Application Ref:	3/2026/0354			 Ribble Valley Borough Council www.ribblevalley.gov.uk
Date Inspected:	26/06/26	Site Notice:	26/06/26	
Officer:	AR			
DELEGATED ITEM FILE REPORT:				
				APPROVAL

Development Description:	Proposed demolition of existing side extension and rear conservatory. Construction of new two-storey side extension and single-storey rear extension.
Site Address/Location:	13 Brookside Old Langho BB6 8AP

Notes
This drawing is the property of IDC Home Architecture Ltd and copyright is reserved by them. This drawing is not to be copied or disclosed by or to any unauthorised persons without the prior written consent of IDC Home Architecture Ltd.

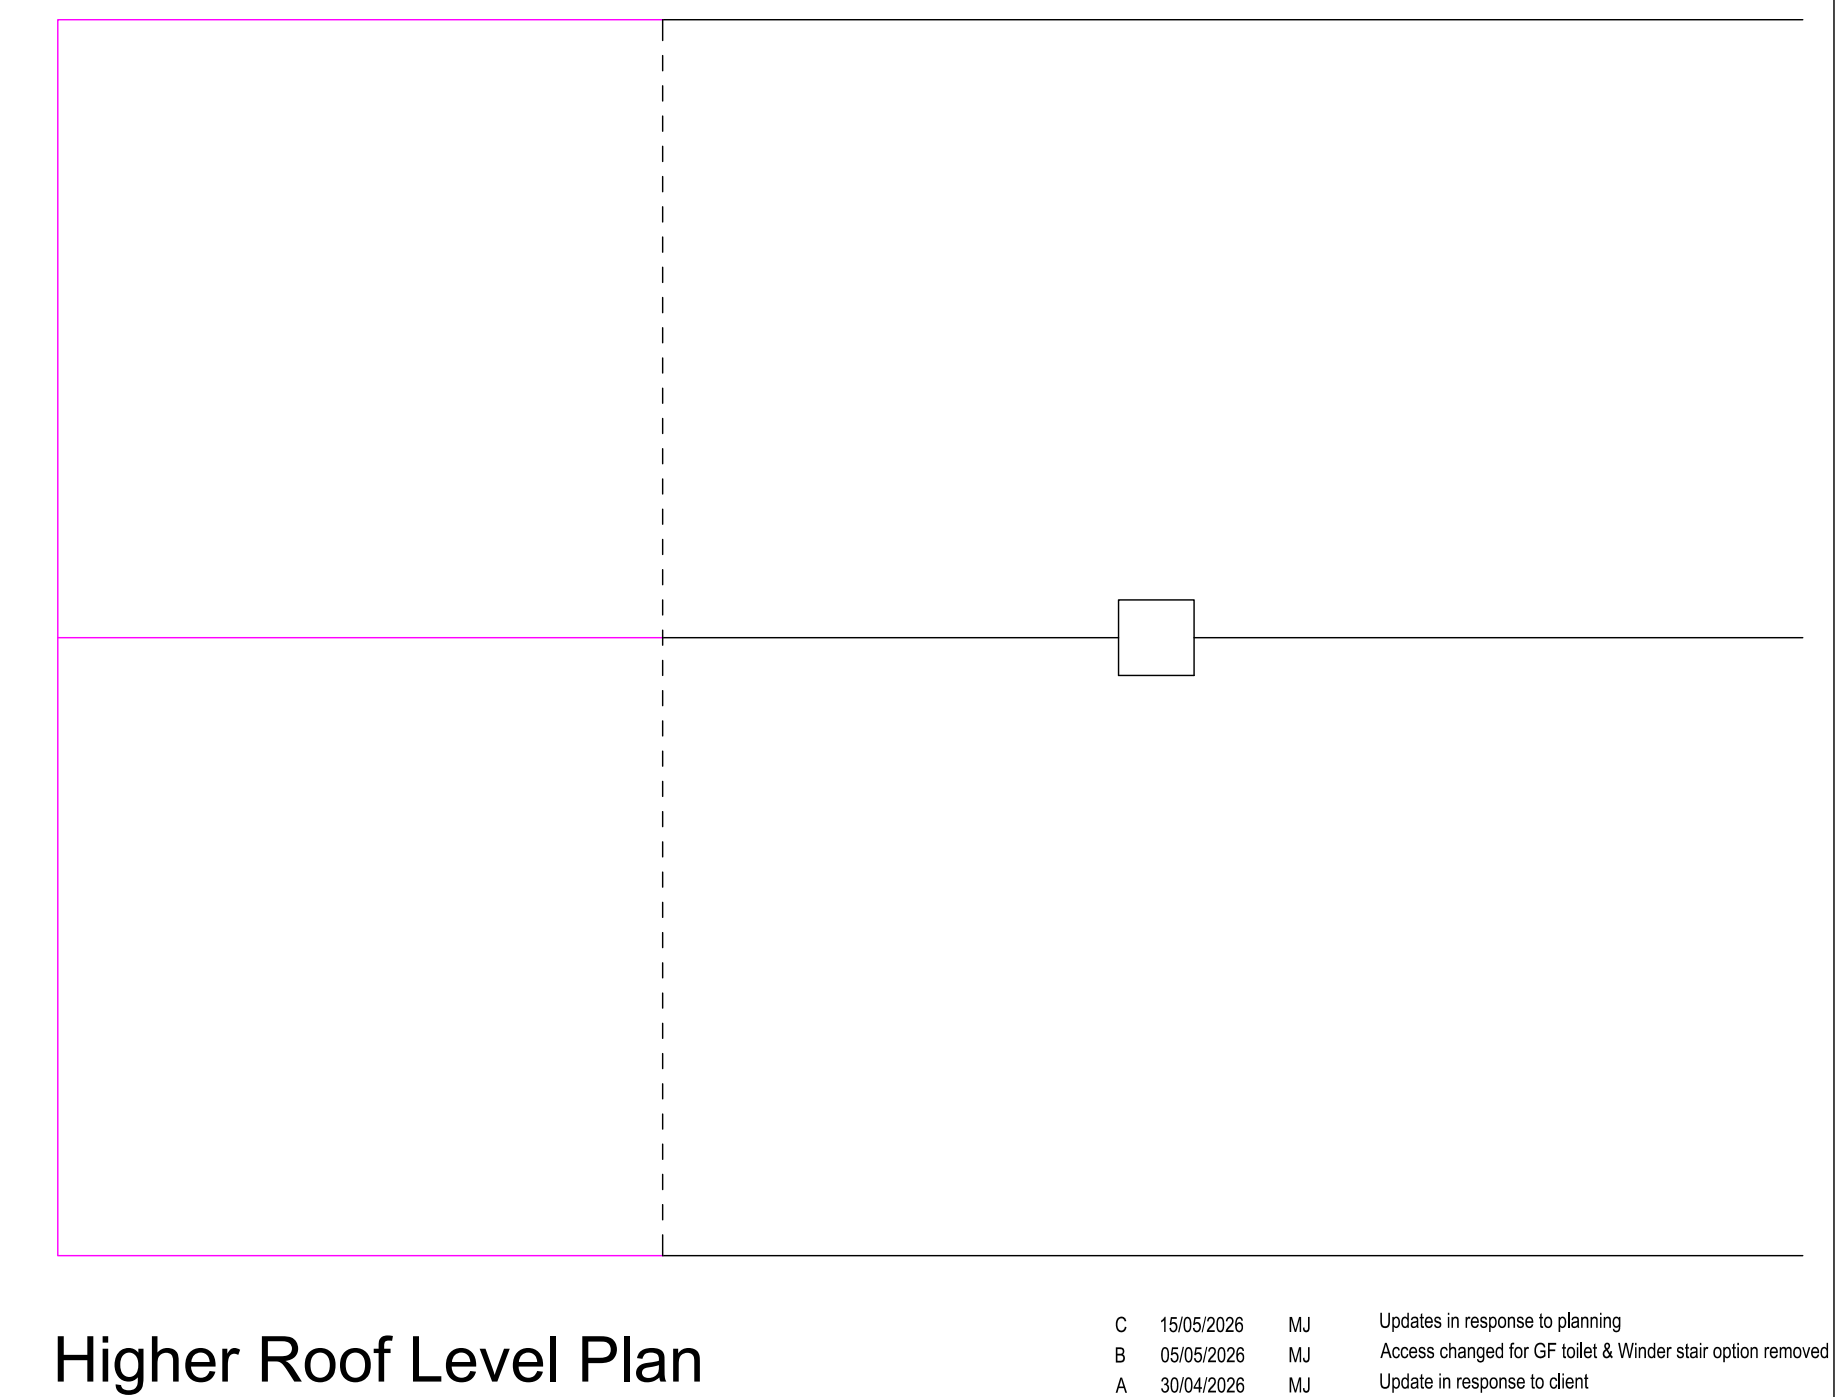
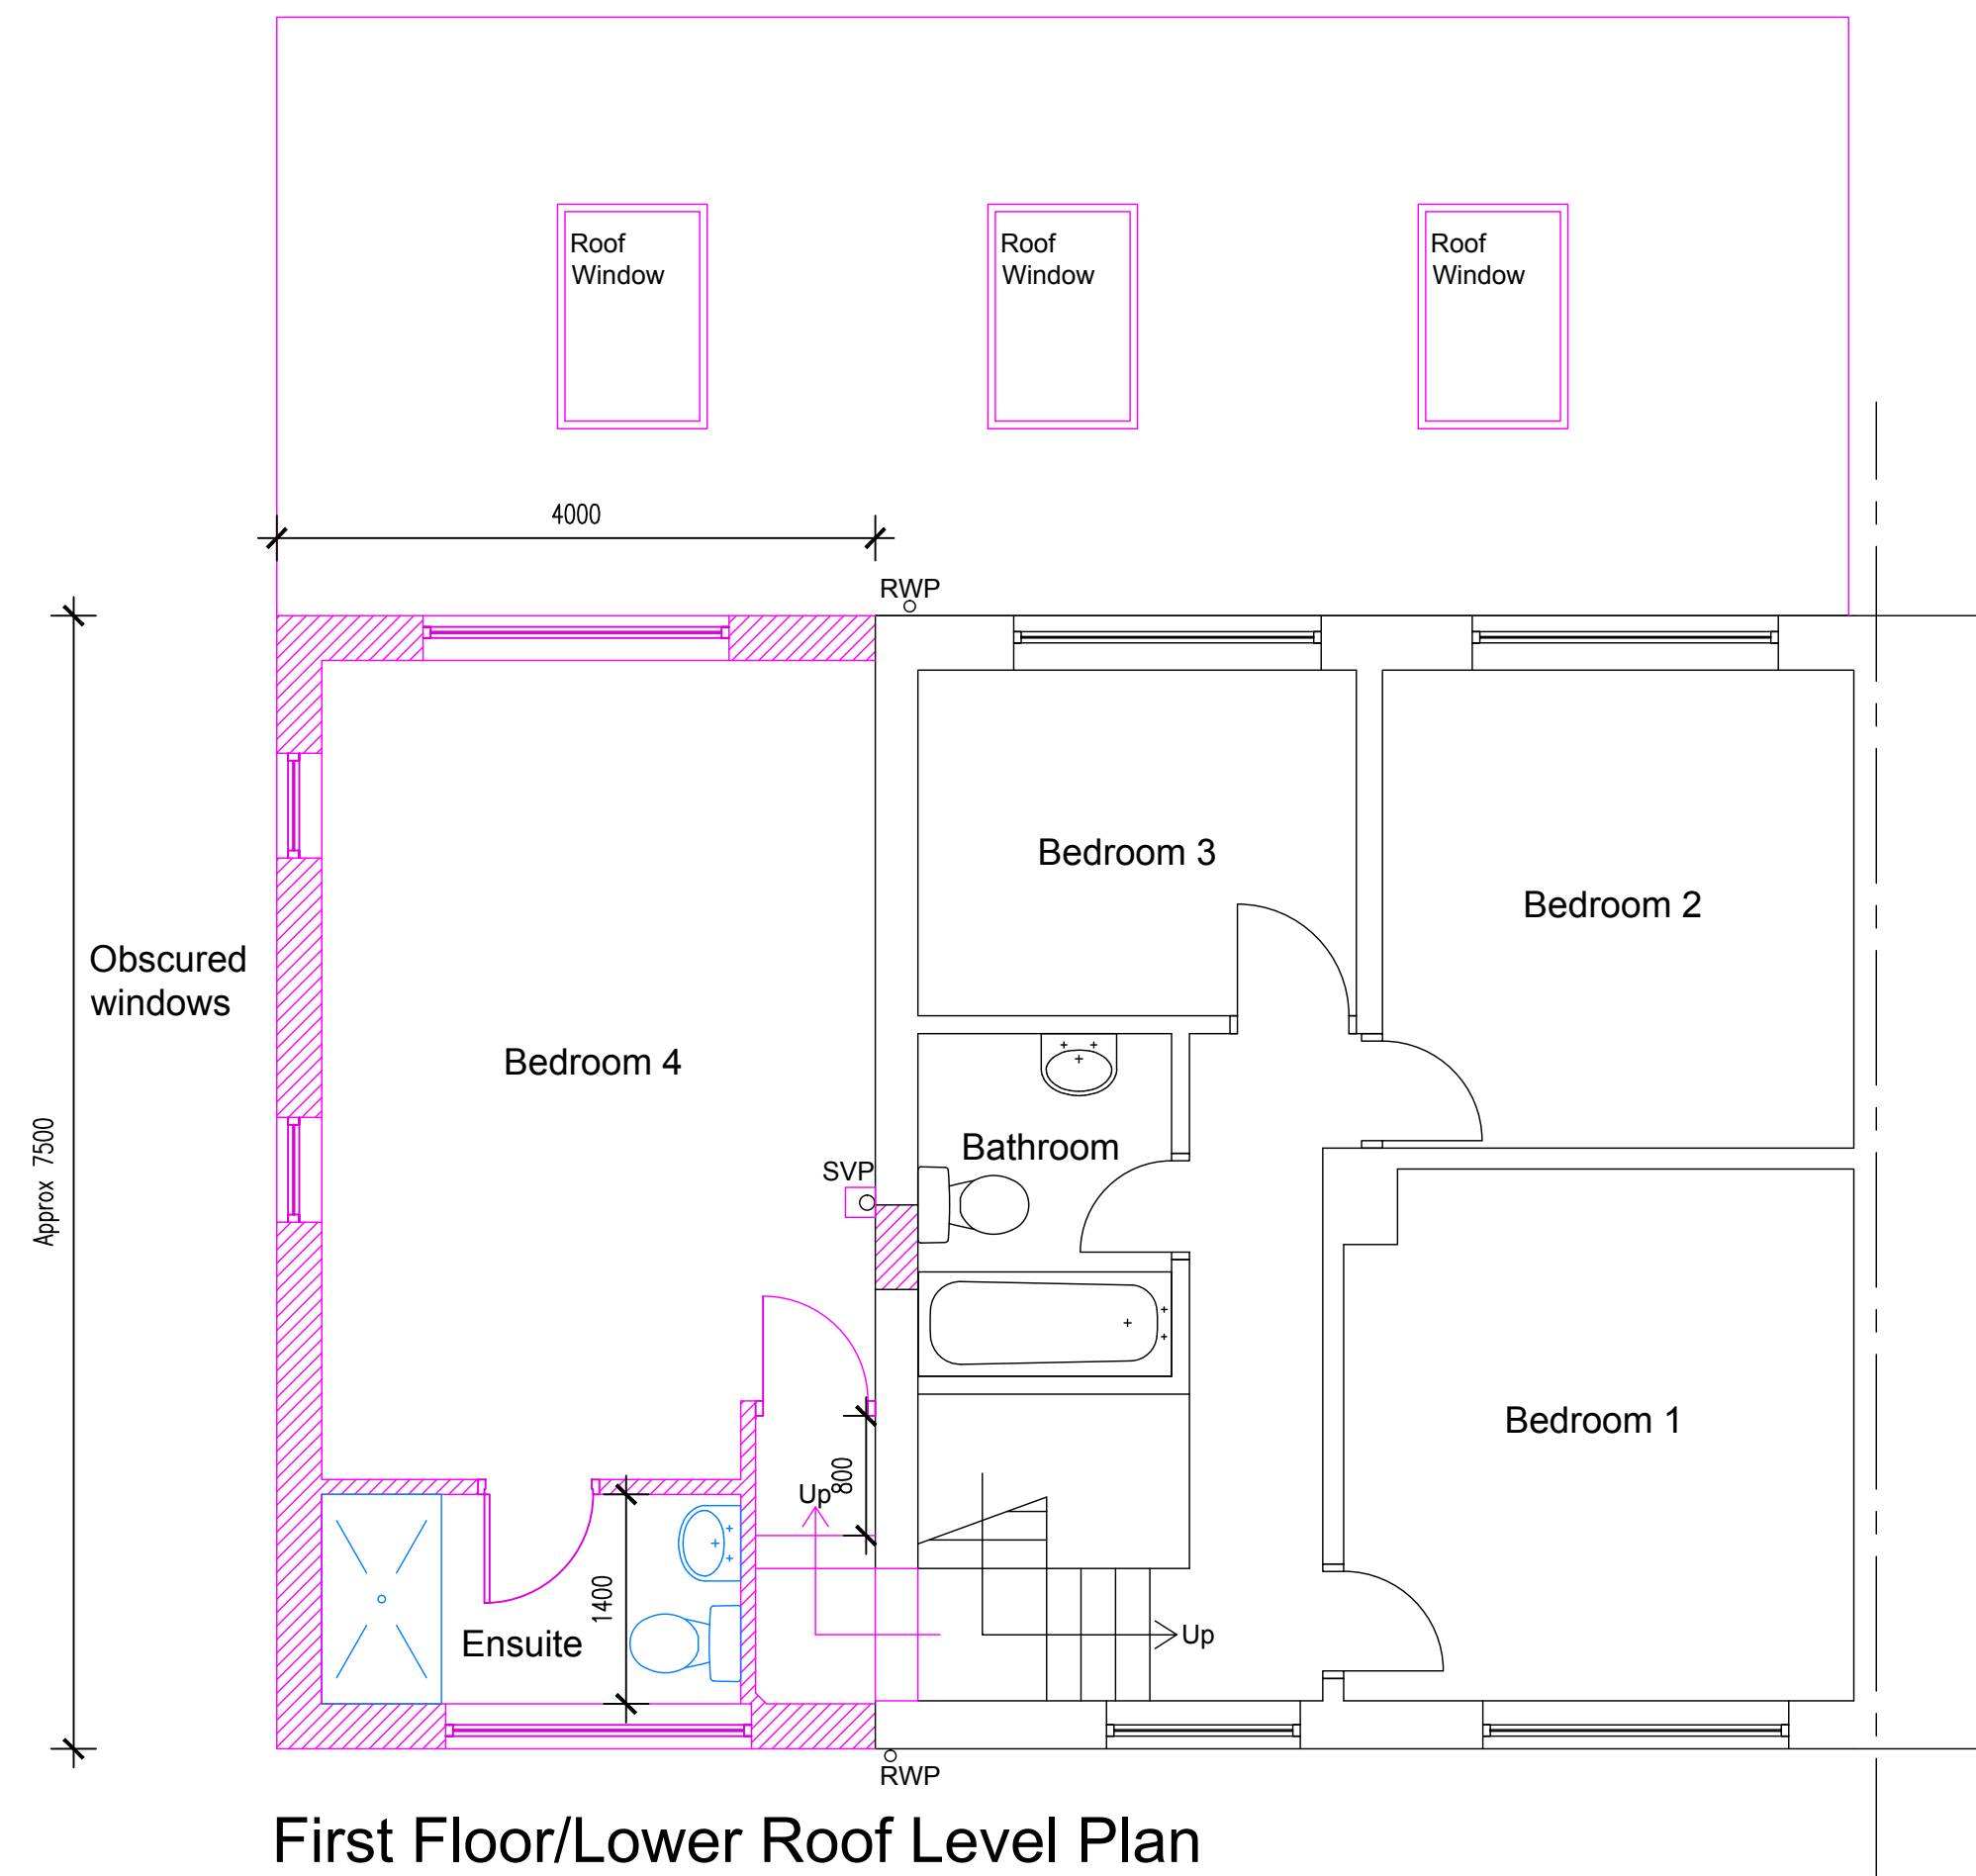
The proposed openings to the front and rear elevations of the two-storey extension would offer views comparable to those currently provided by the existing window arrangement of the main dwelling. The openings proposed to the north-western side elevation would face habitable room windows on the gable elevation of the adjacent property at No. 12 Brookside. However, these new proposed openings would be set approximately 9 metres from the first-floor windows on No. 12 Brookside’s side elevation. To mitigate any potential impacts on privacy, it is recommended that these windows be conditioned to be obscure glazed.

Ordinarily, the Local Planning Authority seeks to ensure that two-storey extensions are both set down from the main ridgeline and set back from the principal elevation. This approach is intended to ensure that extensions appear subservient to the main dwelling. In this case, such amendments were requested prior to determination; however, the applicant did not submit revised plans addressing the planning officer’s concerns regarding potential visual impact. As a result, the proposed extension would be flush with both the principal elevation and the main ridgeline of the dwelling.
